CITY OF ALBUQUERQUE

March 31, 2017

**Re: Galles Chevrolet
Erosion and Sediment Control Plan
Engineer's Stamp Date 3-20-17 (H15E065)**

EROSION
AND
SEDIMENT
CONTROL
PLAN
ESC 101

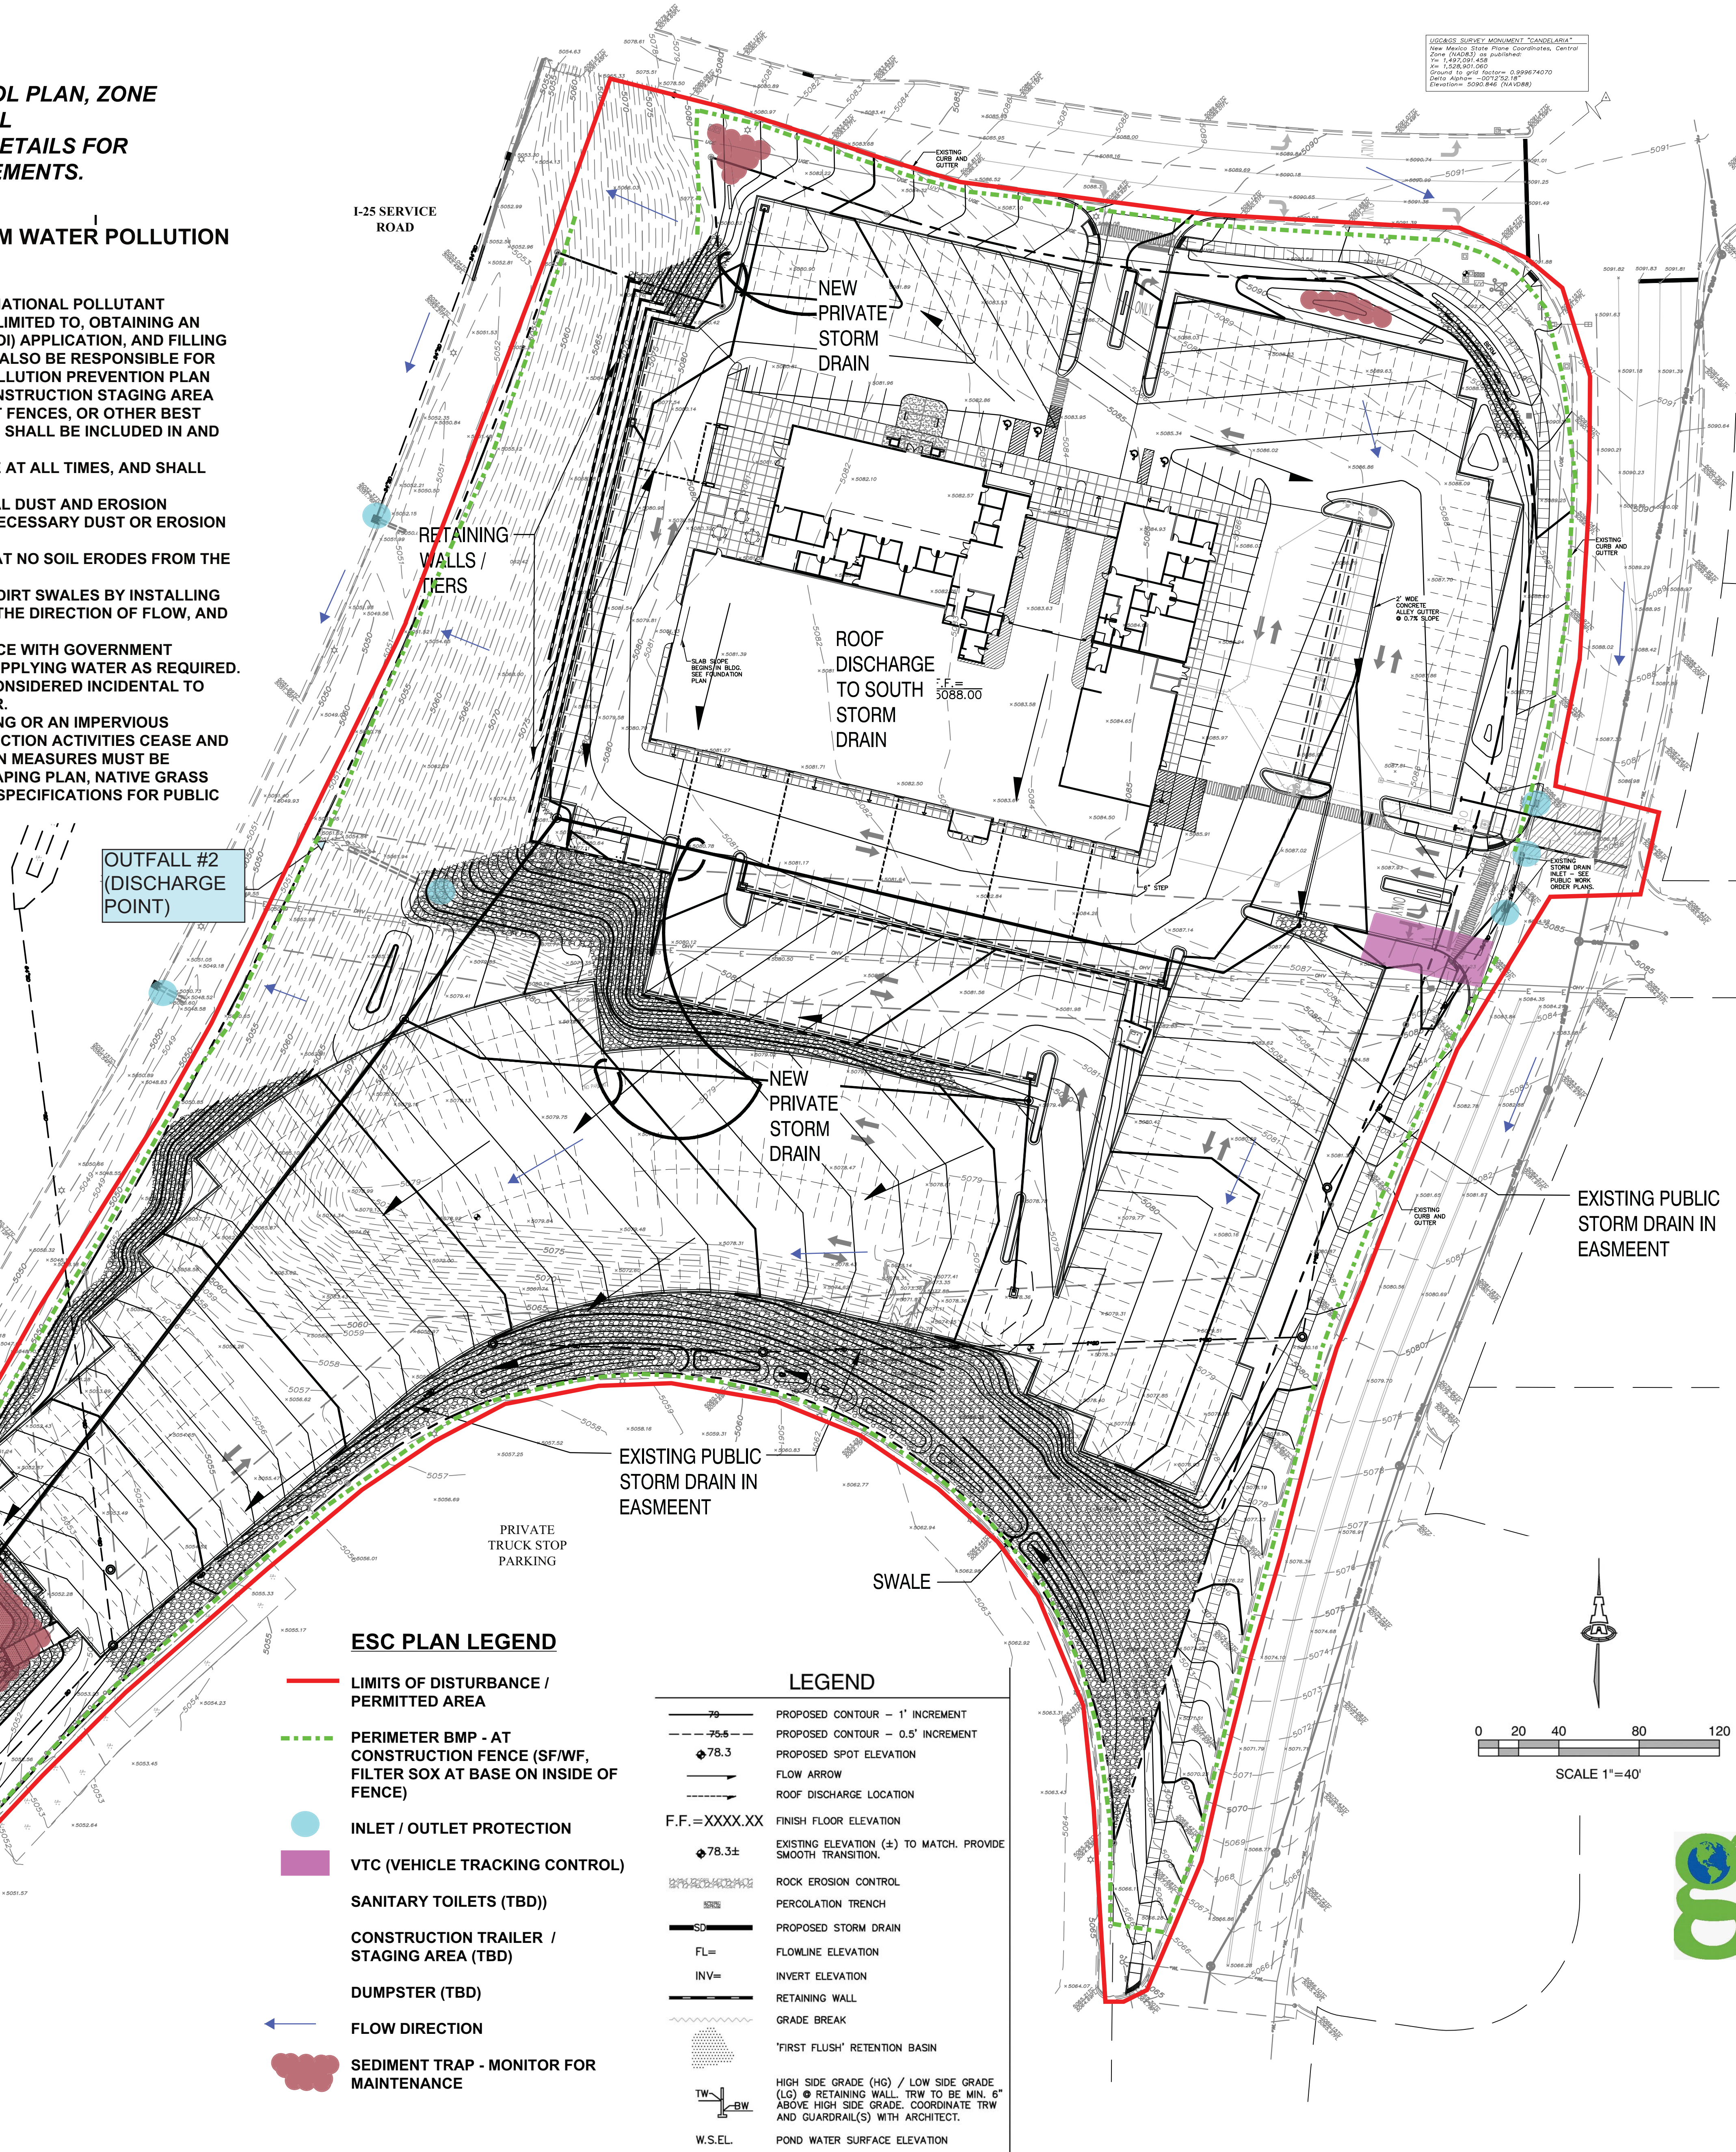
Please consider straw wattles or similar erosion protection on the slopes in the southwest area and grading the pond in the southwest corner early in the development process.
